WSCC CONSULTATION RESPONSE:

County Planning – Minerals & Waste Planning Authority

TO:	Arun District Council Case Officer: Raymond Cole
DATE:	20 August 2021
LOCATION:	Ford Airfield, Ford
SUBJECT:	F/4/20/OUT: Outline planning application (with all matters reserved except for access) for the development of up to 1,500 dwellings (Use Class C3), 60-bed care home (Use Class C2), up to 9,000 sqm of employment floorspace (Use Classes B1), local centre of up to 2,350 sqm including up to 900 sqm retail / commercial (Use Classes A1-A5) and 1,450 sqm community / leisure floorspace (Use Classes D1-D2), land for a two-form entry primary school (Use Class D1), public open space, allotments, new sports pitches and associated facilities, drainage, parking and associated access, infrastructure, landscape, ancillary and site preparation works, including demolition of existing buildings and part removal of existing runway hardstanding.
RECOMMENDATION:	☒ Advice ☒ Objection ☐ Modification ☐ No Objection ☐ More Information ☐ Refusal

Revised Waste Infrastructure Statement (WIS)

Section a-a'

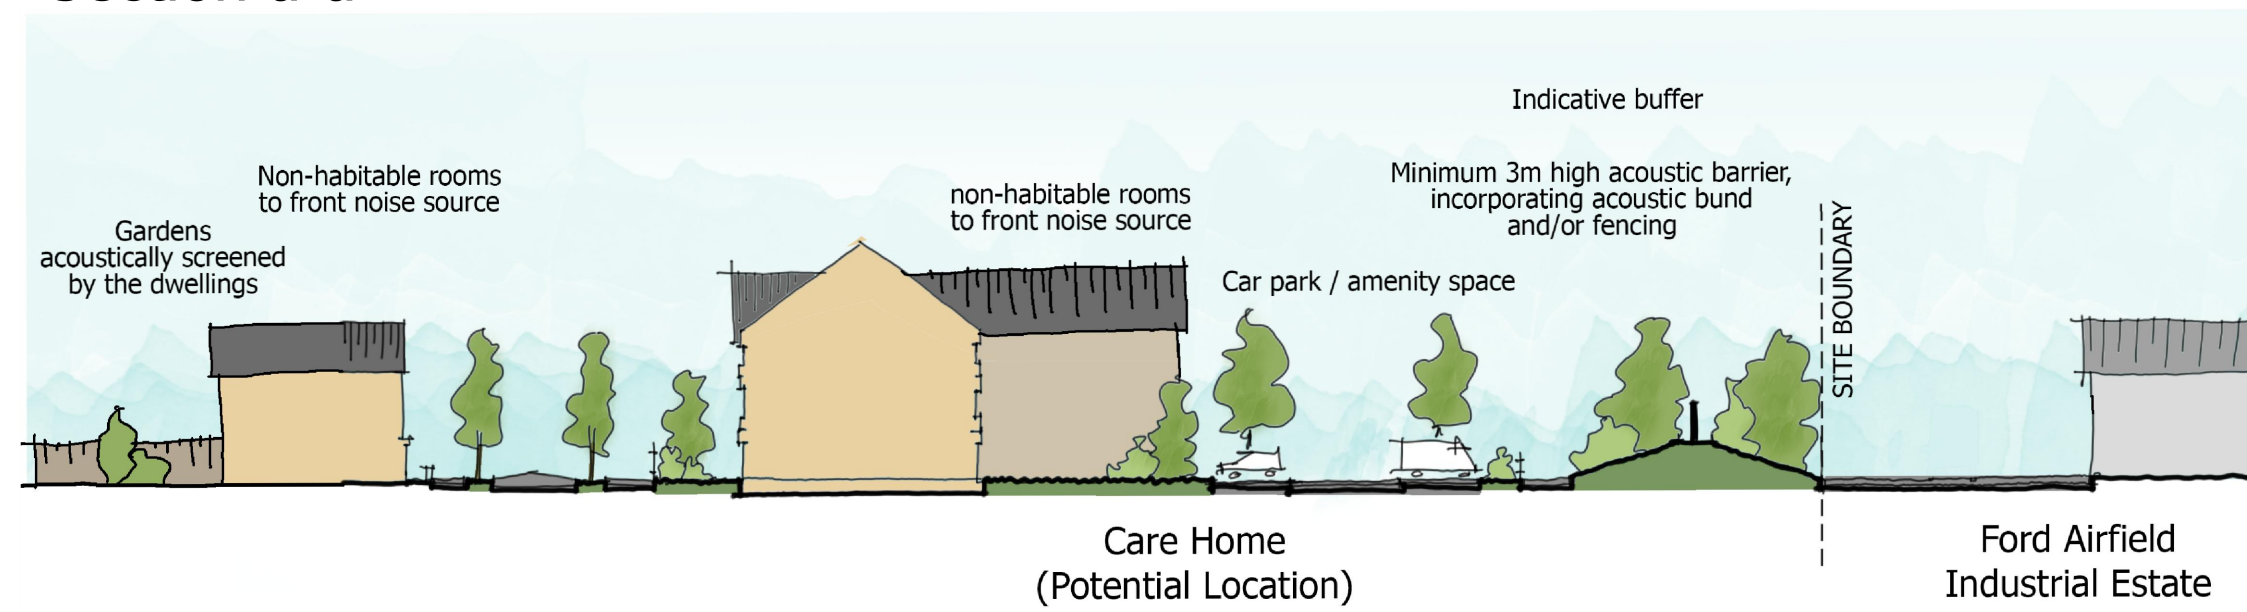
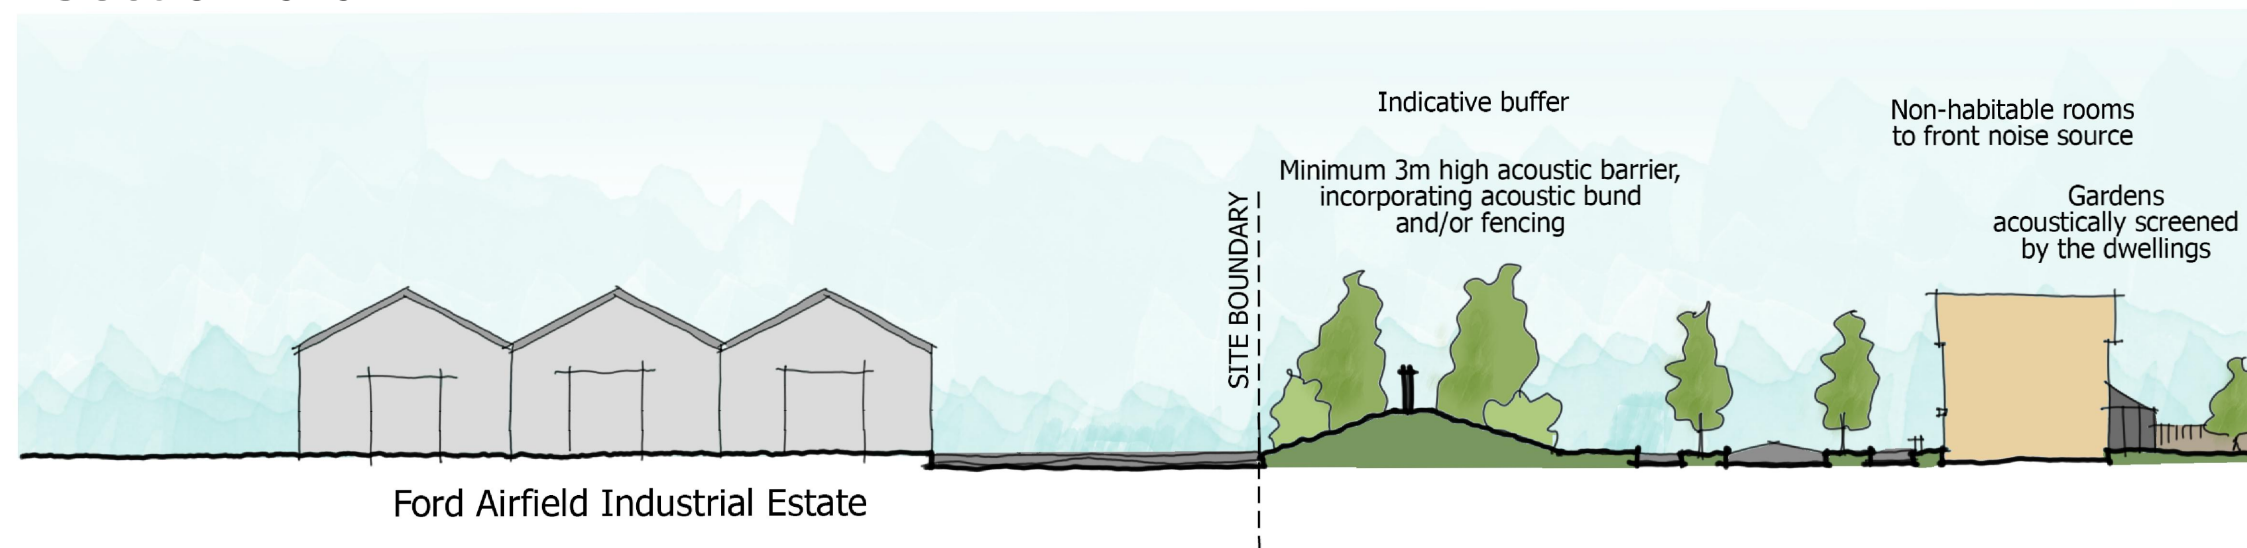
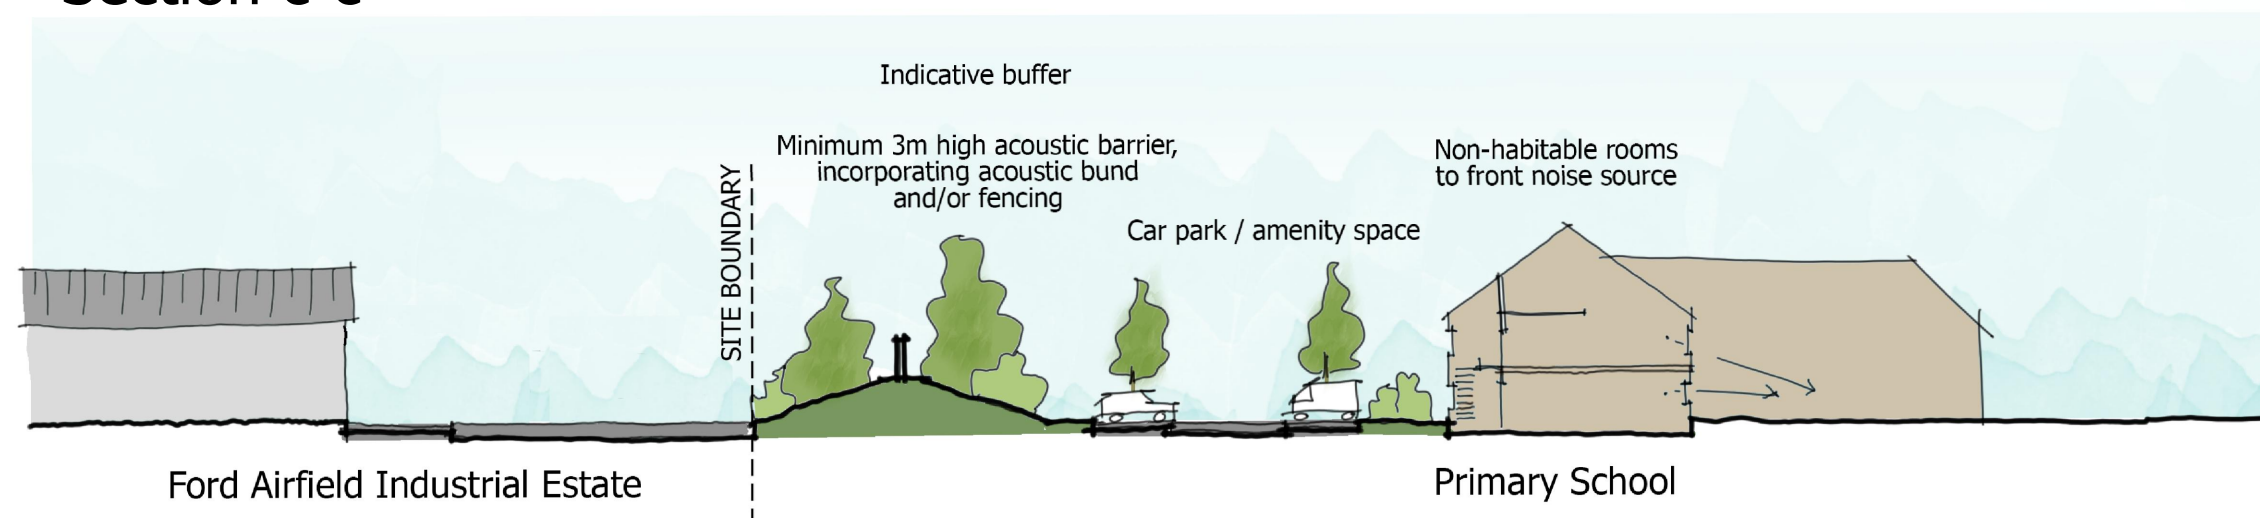
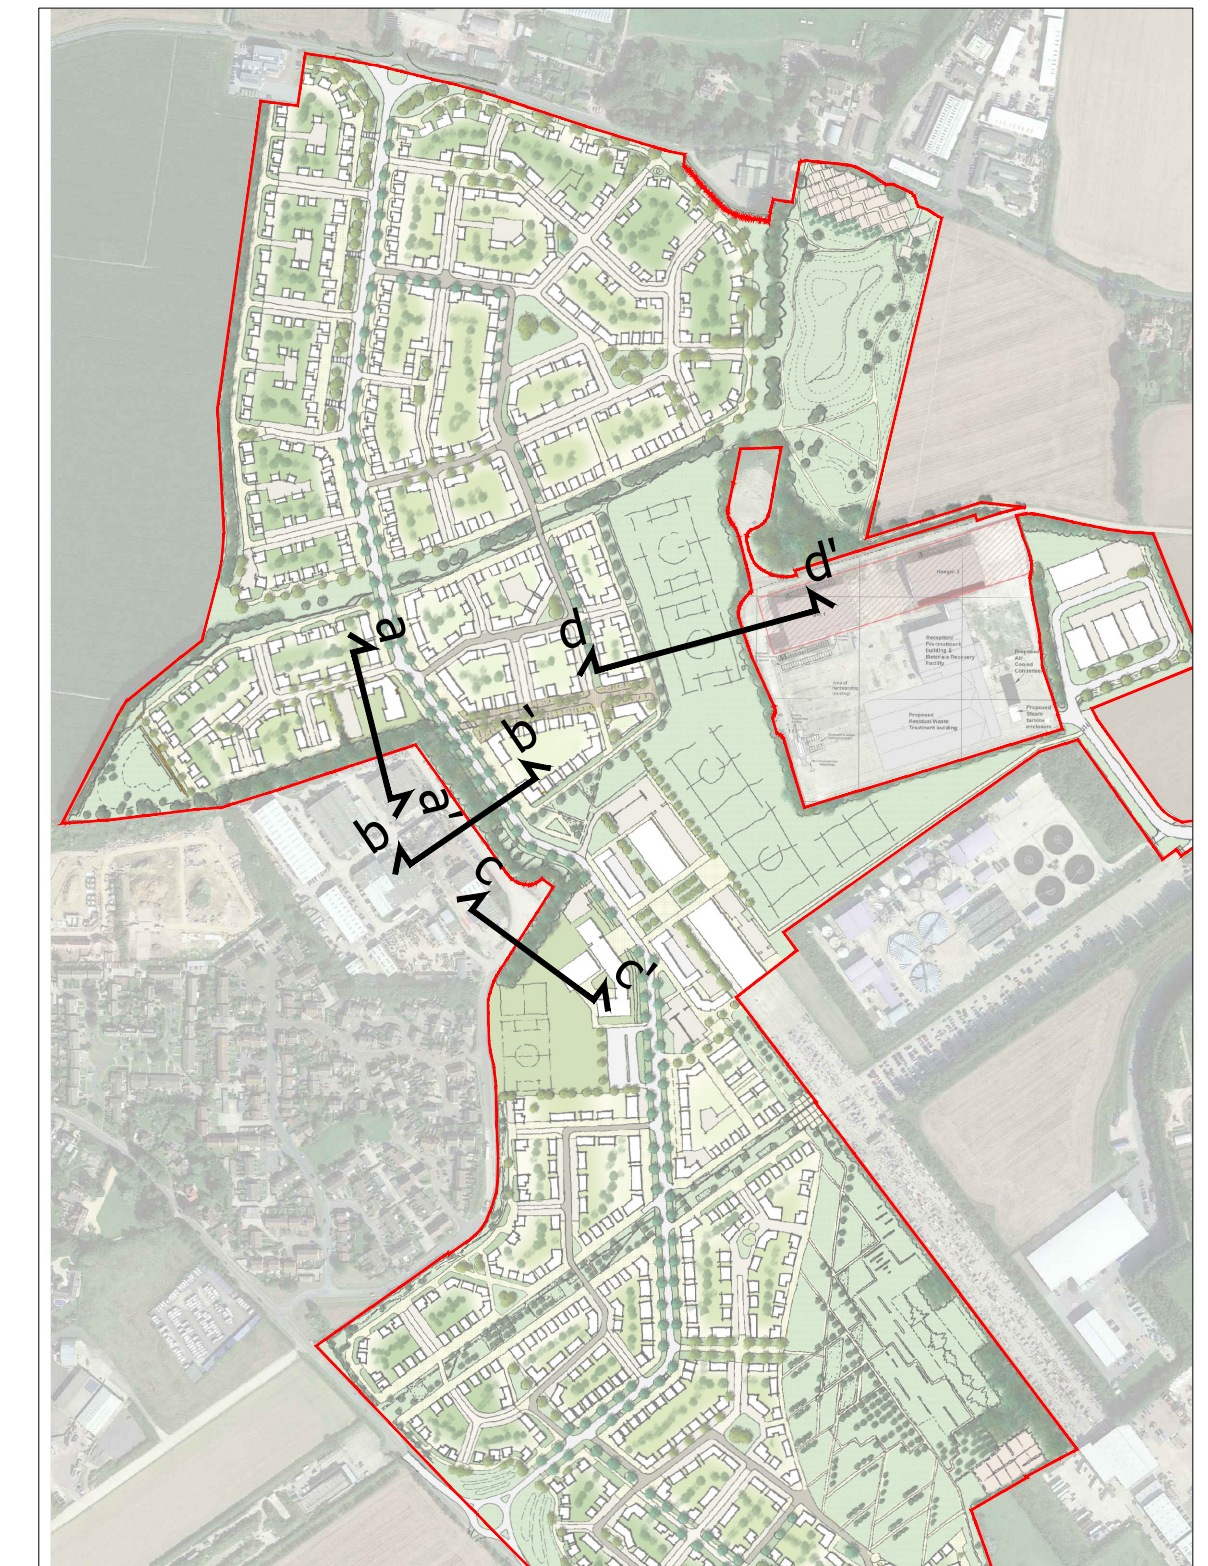
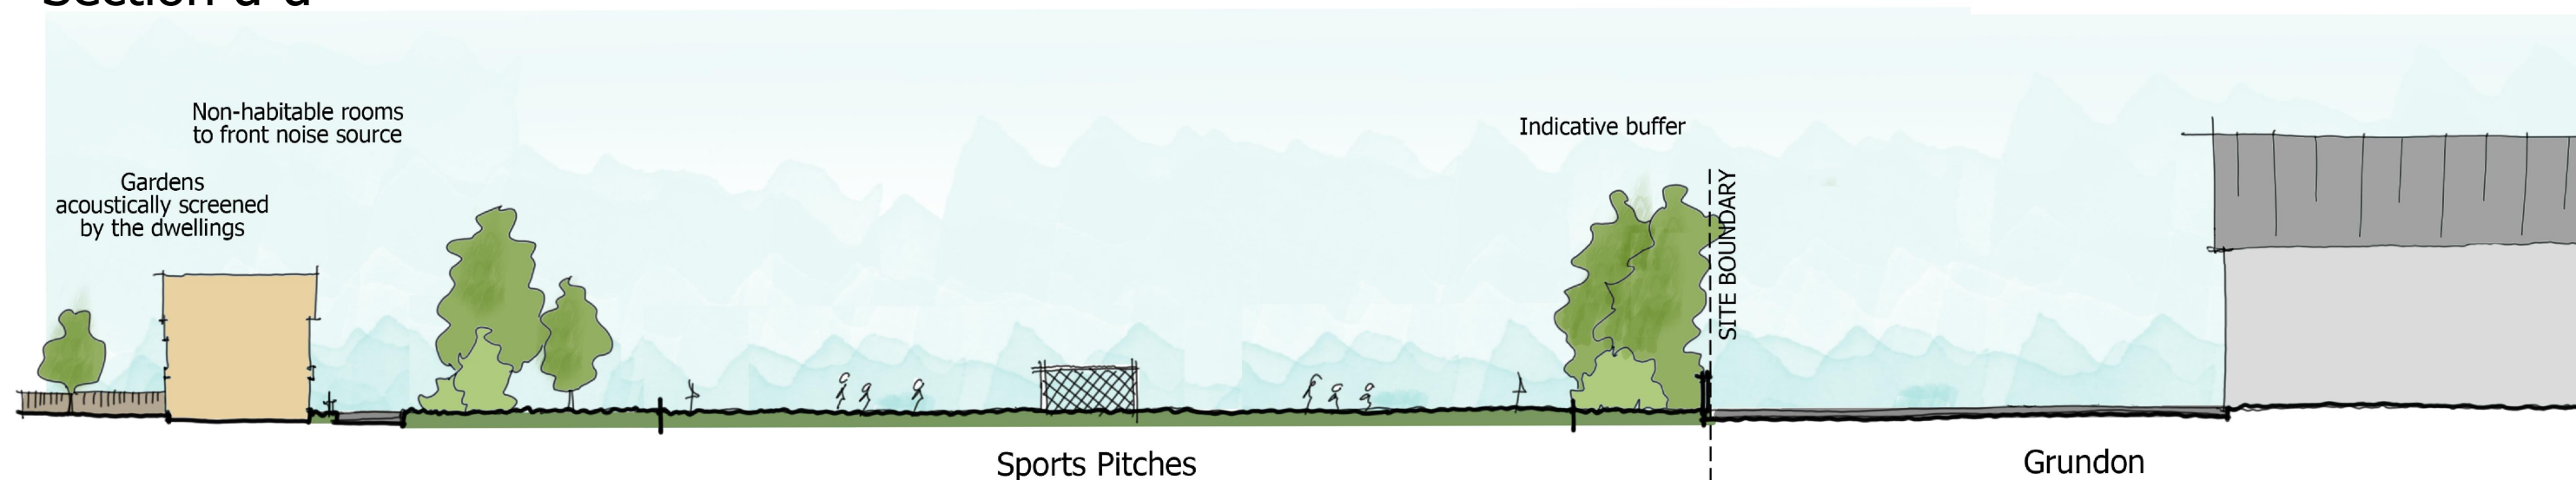
The County Council also retains some concern as to whether indicative orientations/proposed noise mitigation could be achieved and whether the applicant's proposed condition would be sufficiently precise and/or appropriate to secure such measures (particularly if mitigation were to be delivered in phases). In addition, consideration should be given to further opportunities for improvements/increases to landscape buffers with neighbouring waste sites. This is particularly important where it could soften views of existing and future waste management facilities and/or complement their boundary treatments, and where existing mature tree belts would be lost (e.g. to the east of the Flying Fortress).

For the avoidance of doubt, the County Council would wish for any outline masterplan (and/or and Land Use Plans) to be based on required buffers and to detail specific noise mitigation features (e.g. barriers) and any areas requiring controlled orientation for noise mitigation.
